Wee Hur Student Housing - 104-116 Regent Street, Redfern –GANSW review of the EIS – 22.02.22

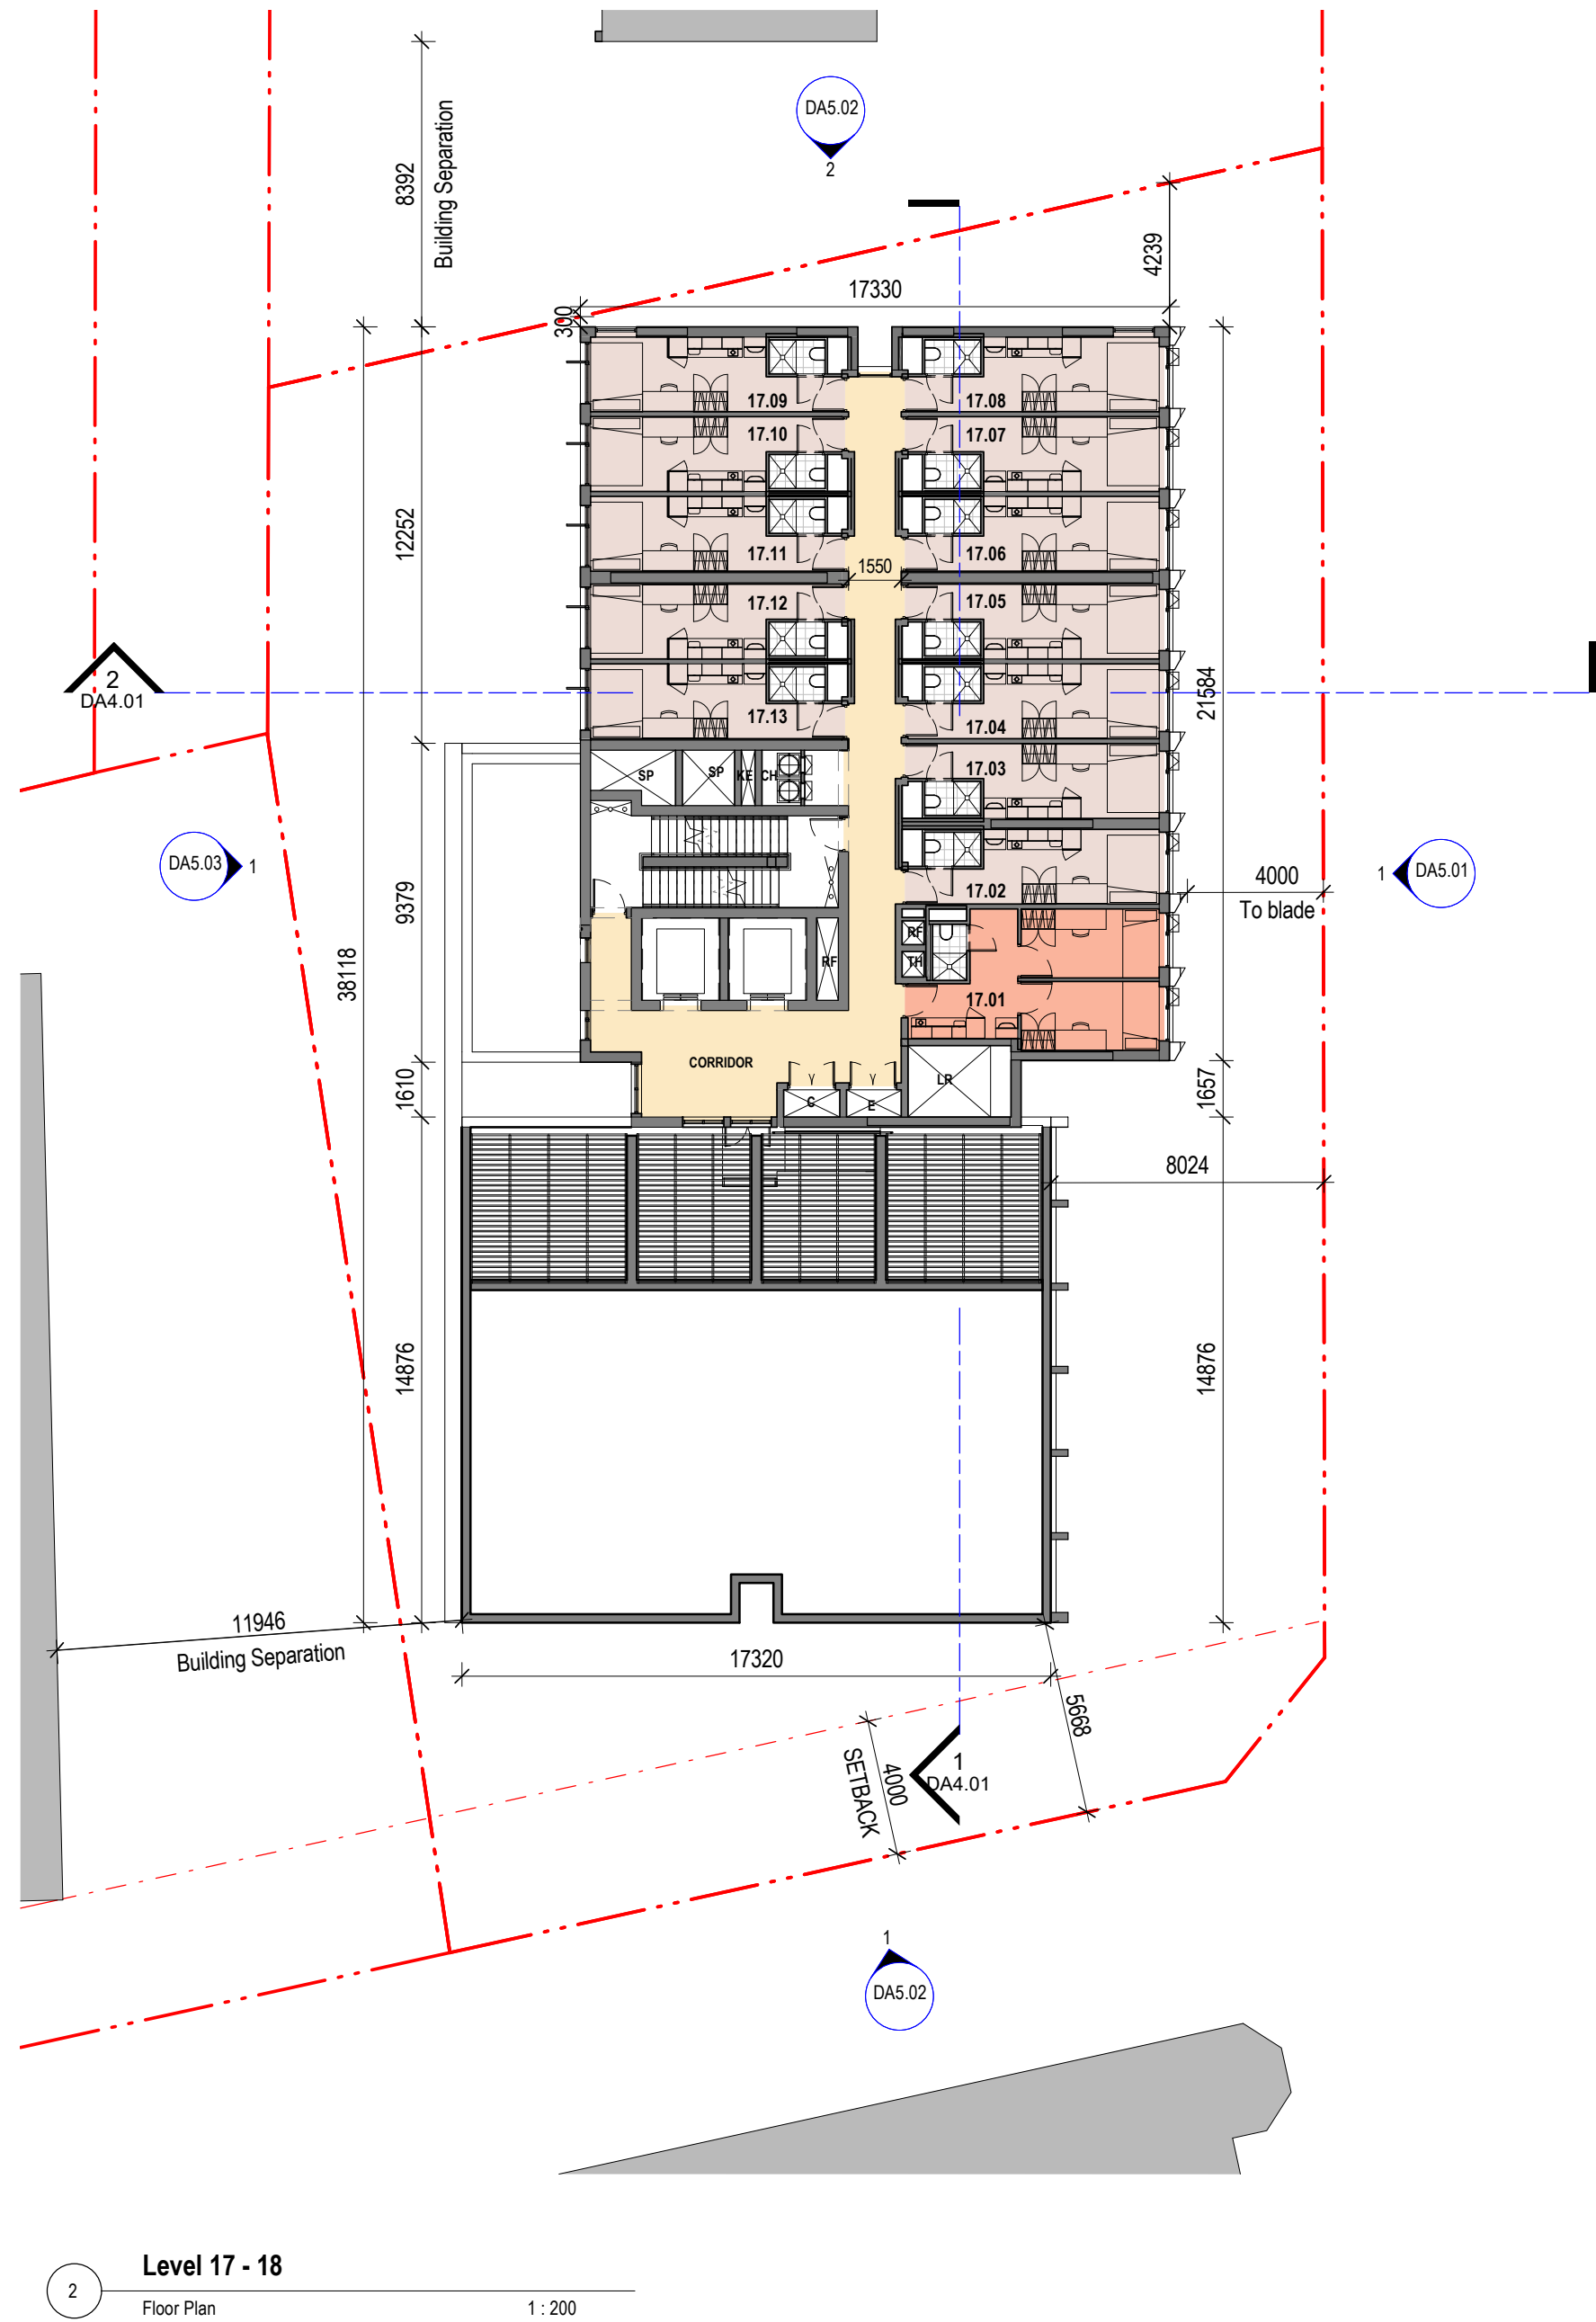
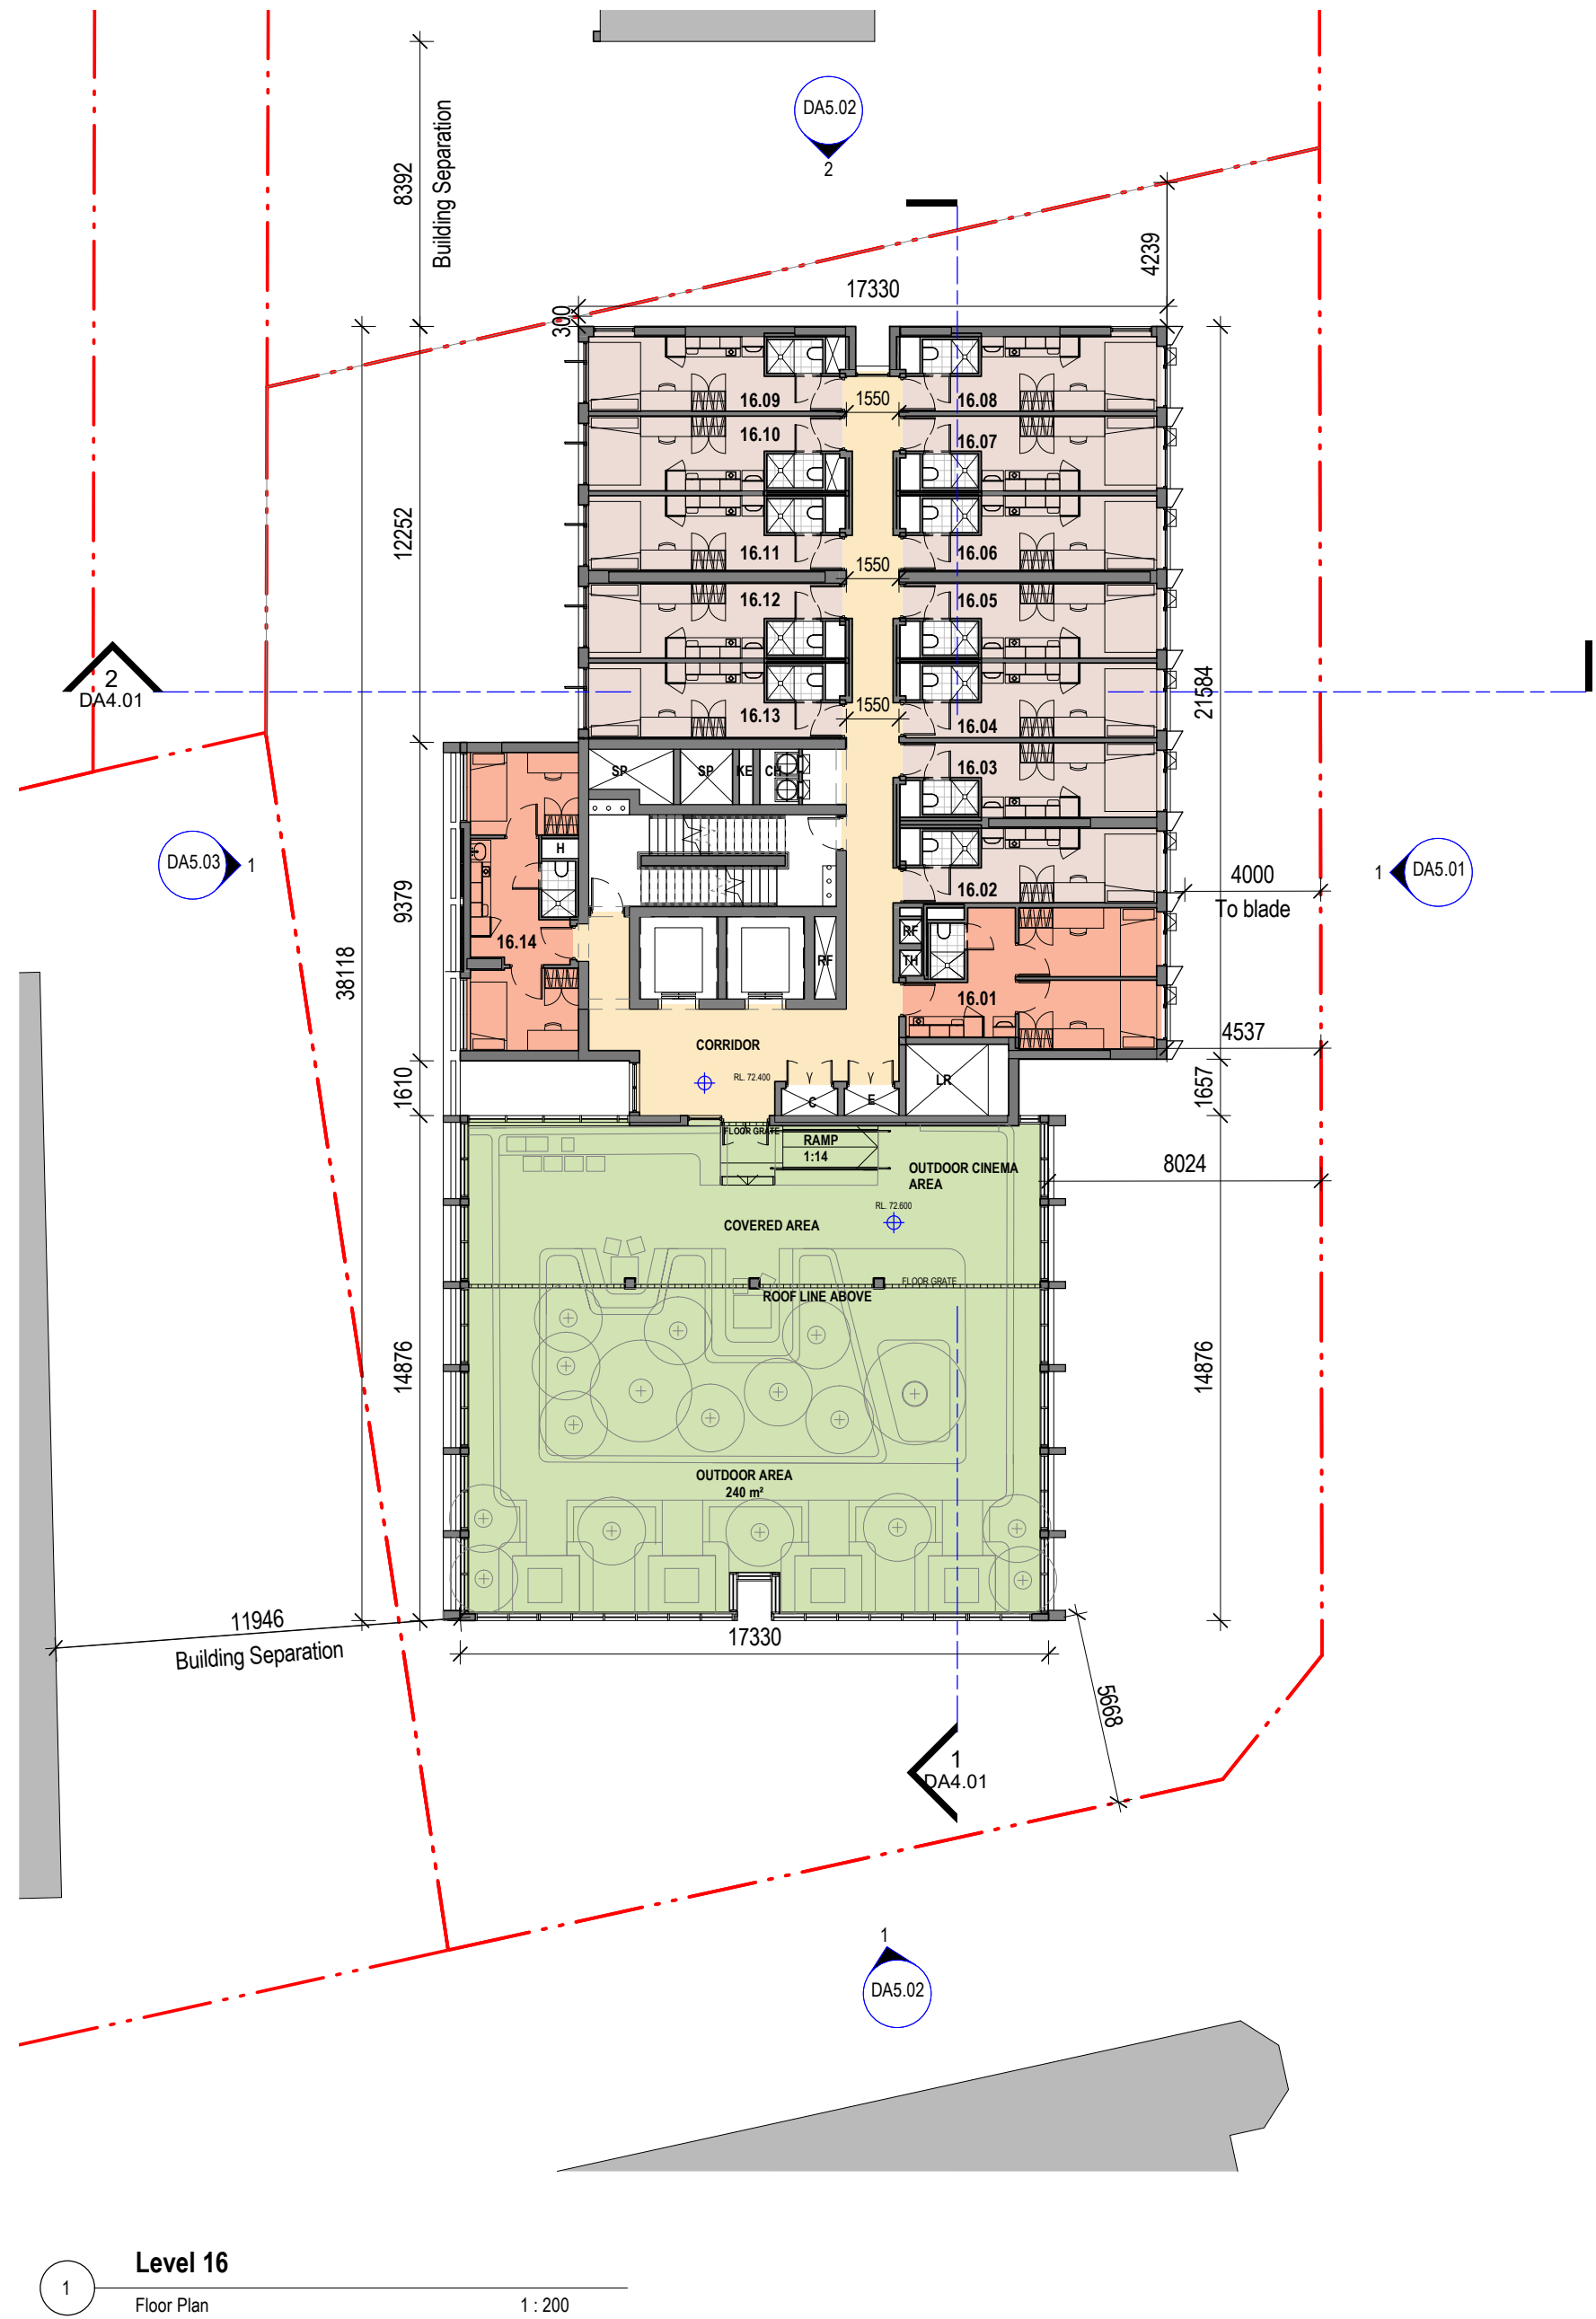
10. Floor plan layouts and spatial planning, advice includes:
 - a. typical tower layouts do not optimise amenity of corridor spaces - for example:

- relocate plant and risers to provide windows immediately adjacent to the lift lobby/waiting areas and
 - take opportunities for corridor windows at upper levels (L16) that are impeded by services cupboards
 - b. It is recommended to provide visual connections between the bike store and the ground floor communal space; noting that shared facilities are often spaces where users may feel '*at risk*'. For example, a visual connections from the service desk/ reception and from the entrance areas of the communal space.
 - c. The long-term flexibility of the ground floor communal space can be improved with greater consideration for the location of services and the accessible ramp.
11. Consider opportunities for shading at rooftop terraces
